Application no: H02-0496-11

Location: Martins Farm
Postland
Crowland
Peterborough
PE6 0JU
PE6 0JU

Amendment: Amended design details (dwg. nos. 300-07-16, -02B, -03A, -04B, -05B, -08A, -09B, -12B, -15A)

Re: Martin's Farm, Postland, Crowland – Your Ref: H02-0496-11 – Conversion of barns into two residential dwellings

Drawing Title:
Elevations - 2

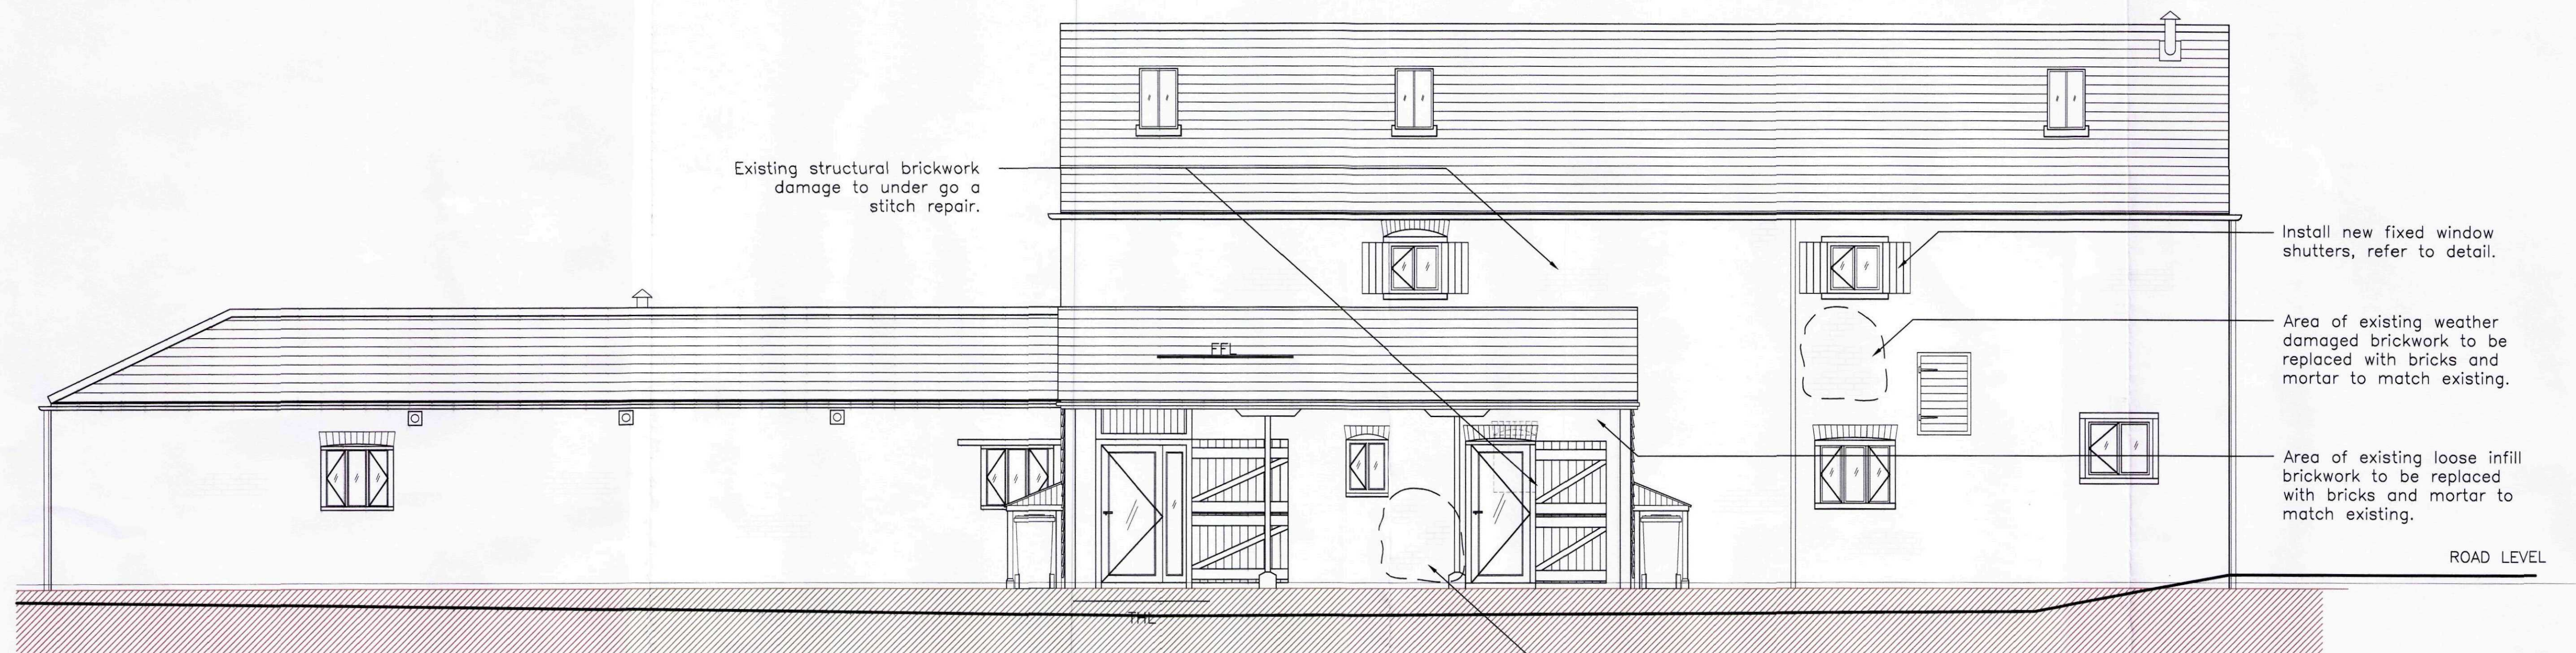
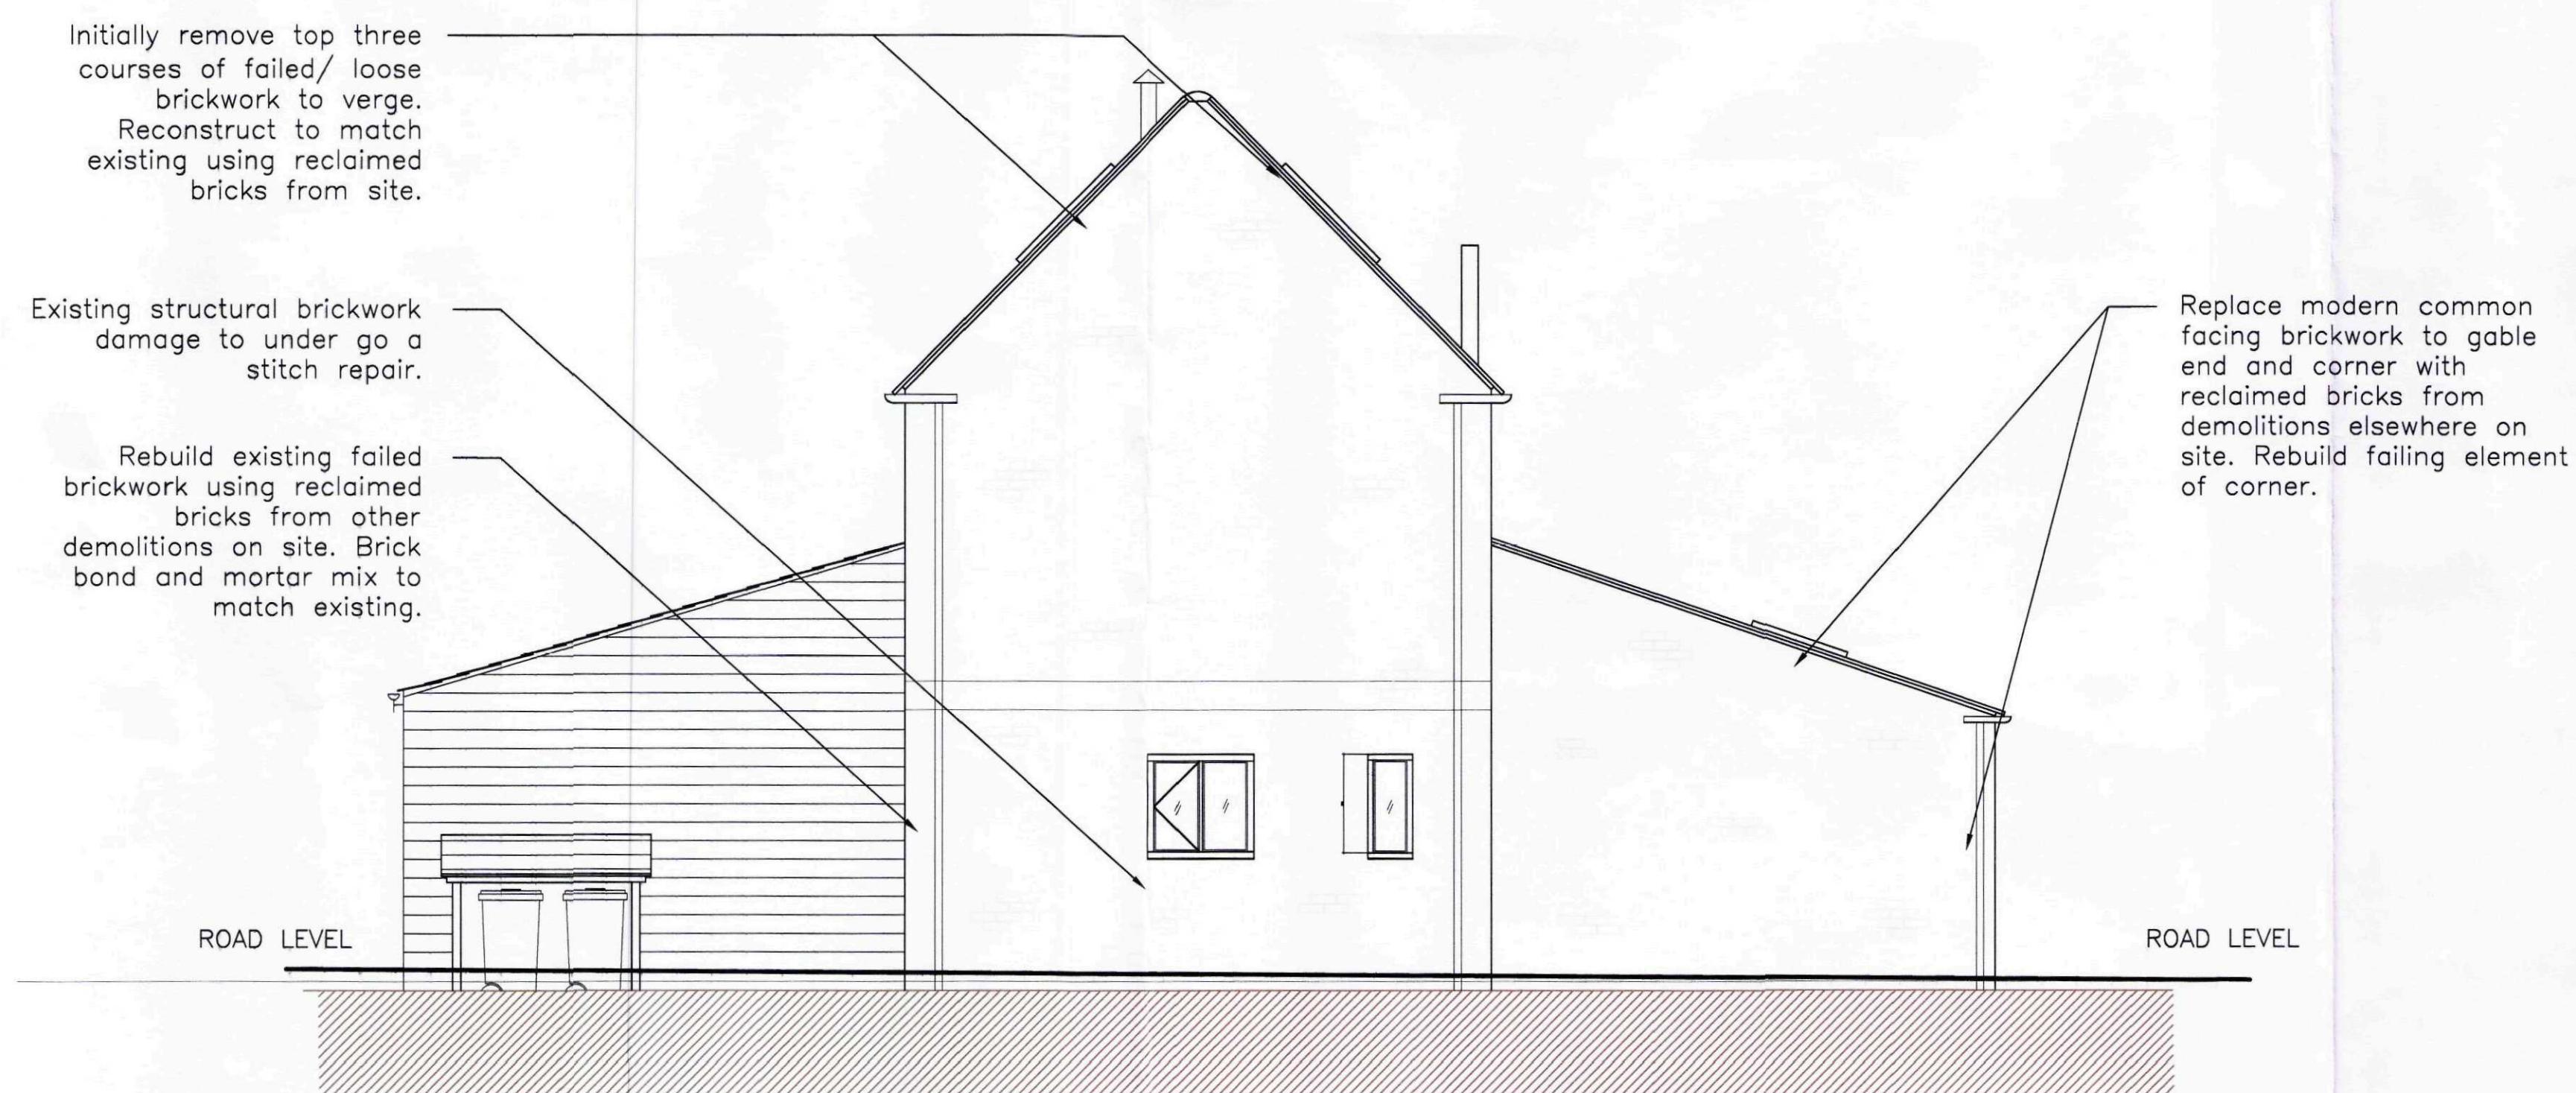
The carport has been revised since our site meeting and revised details are enclosed.

Drawing Title:
Elevations - 1

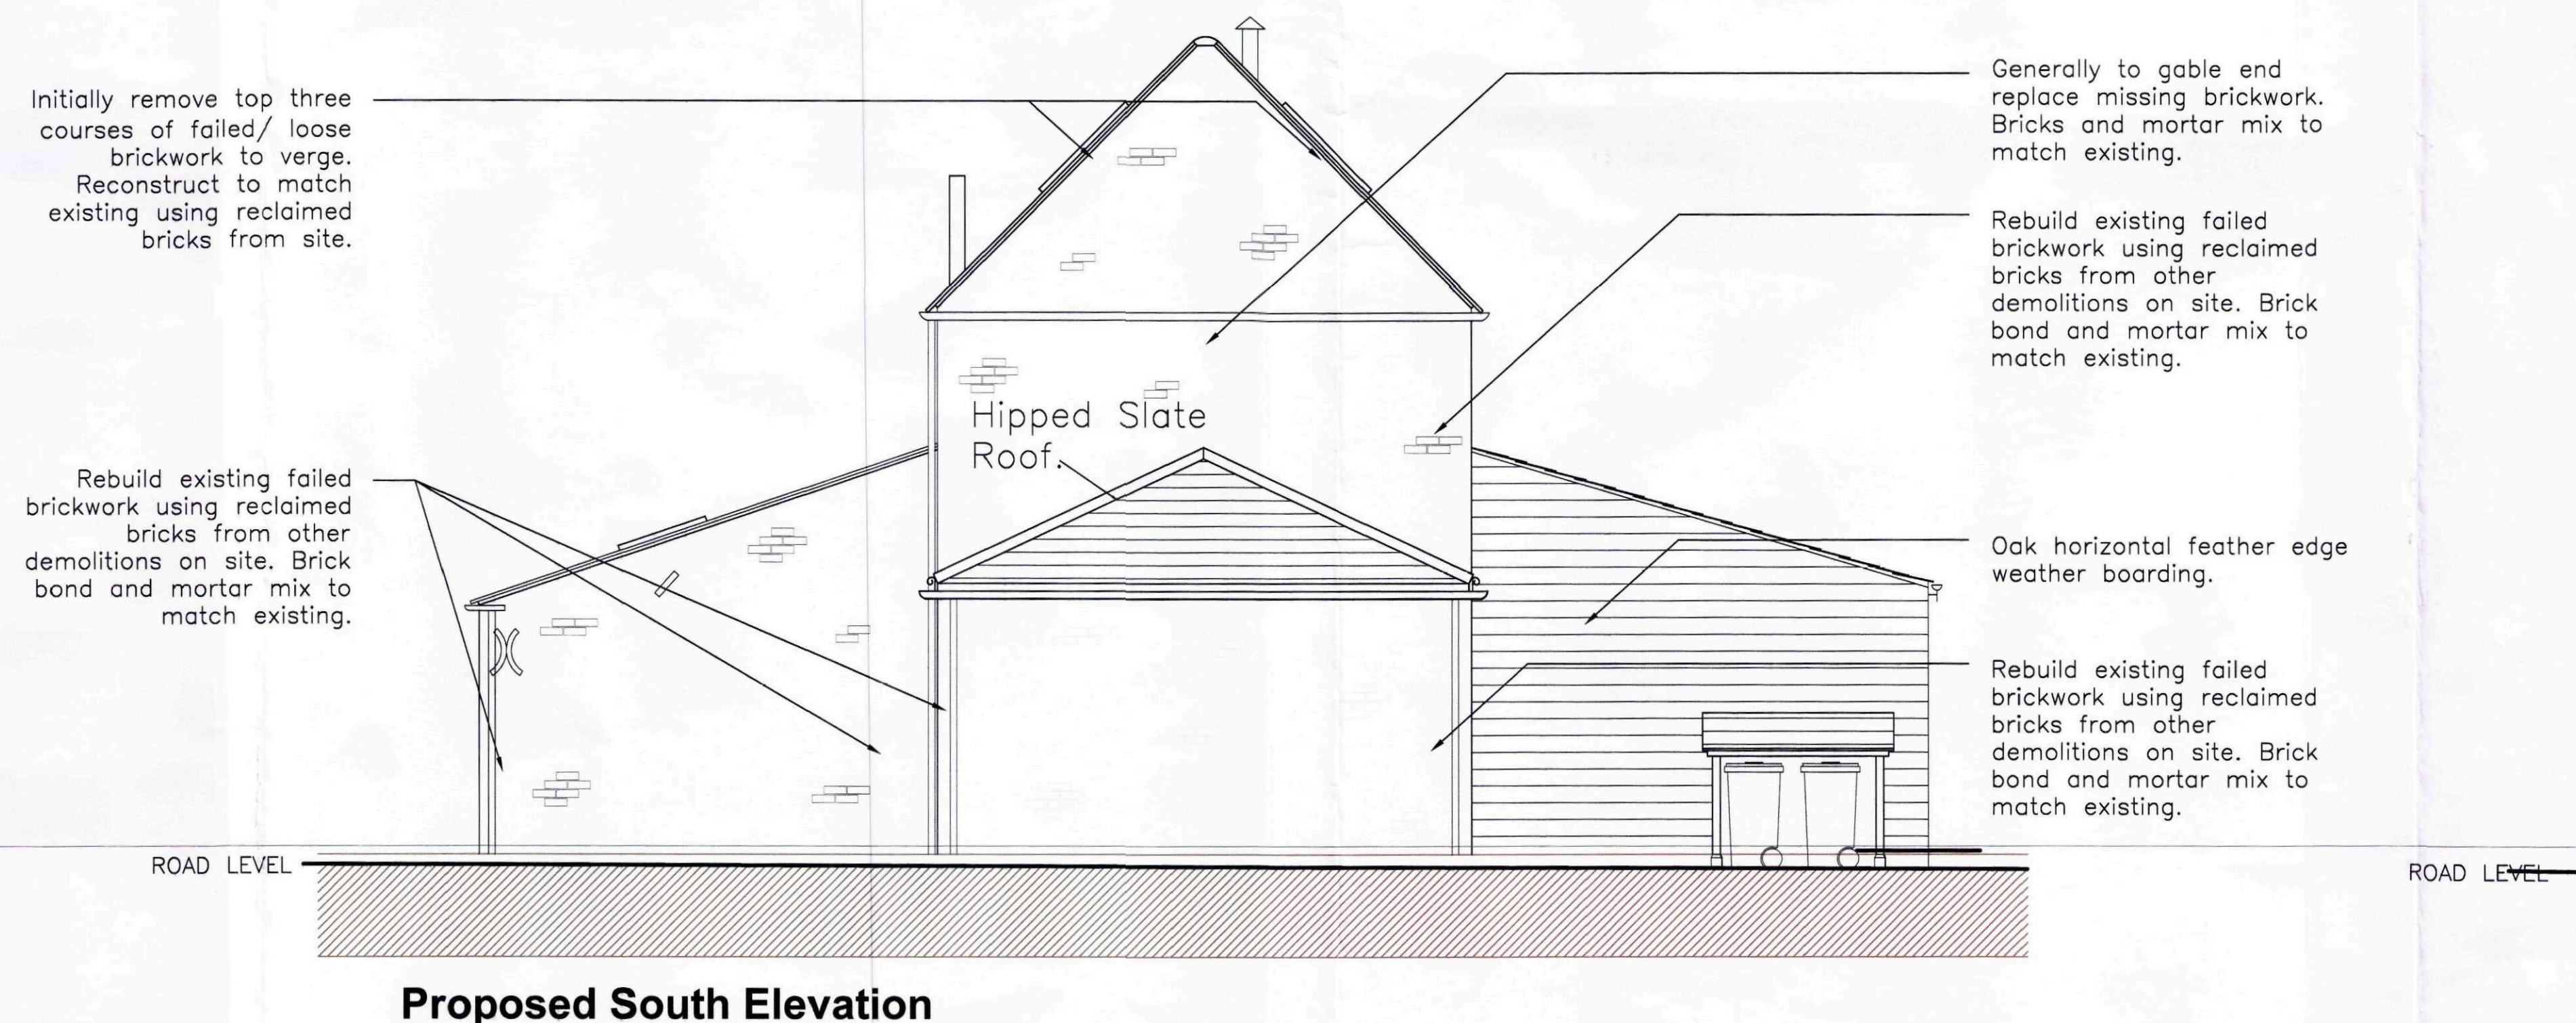
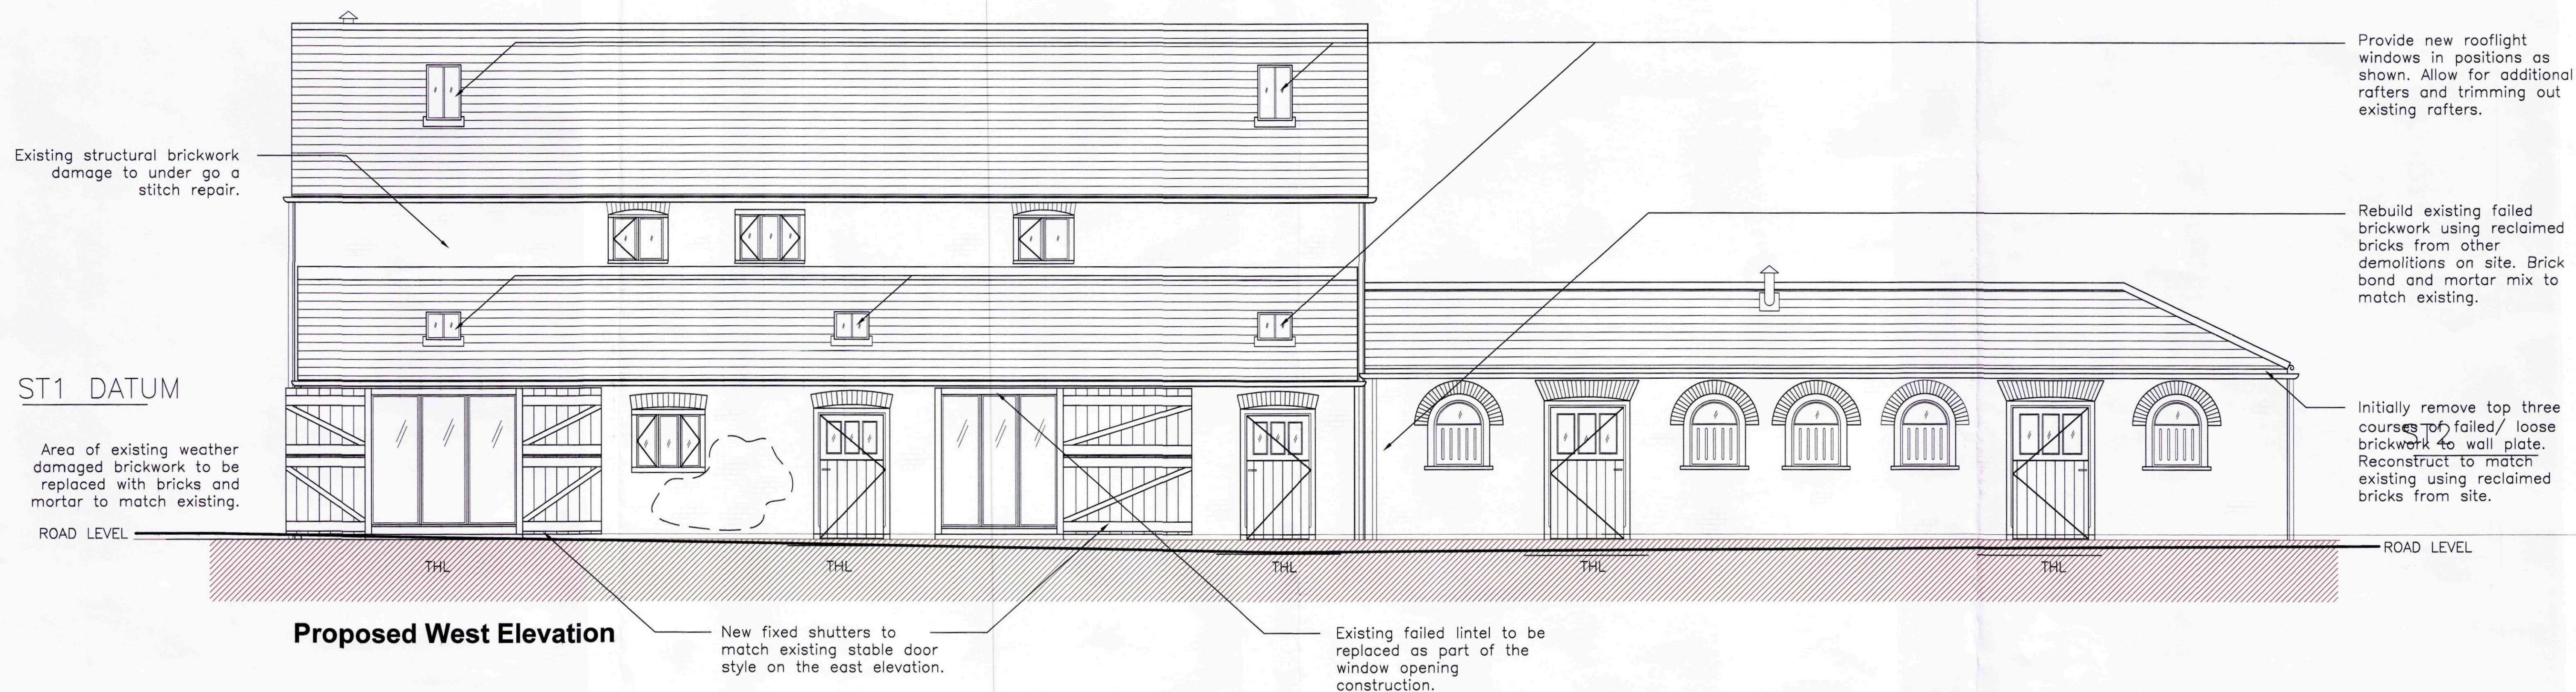
I can confirm that the roof lights are CR-10 as indicated on the revised drawing.
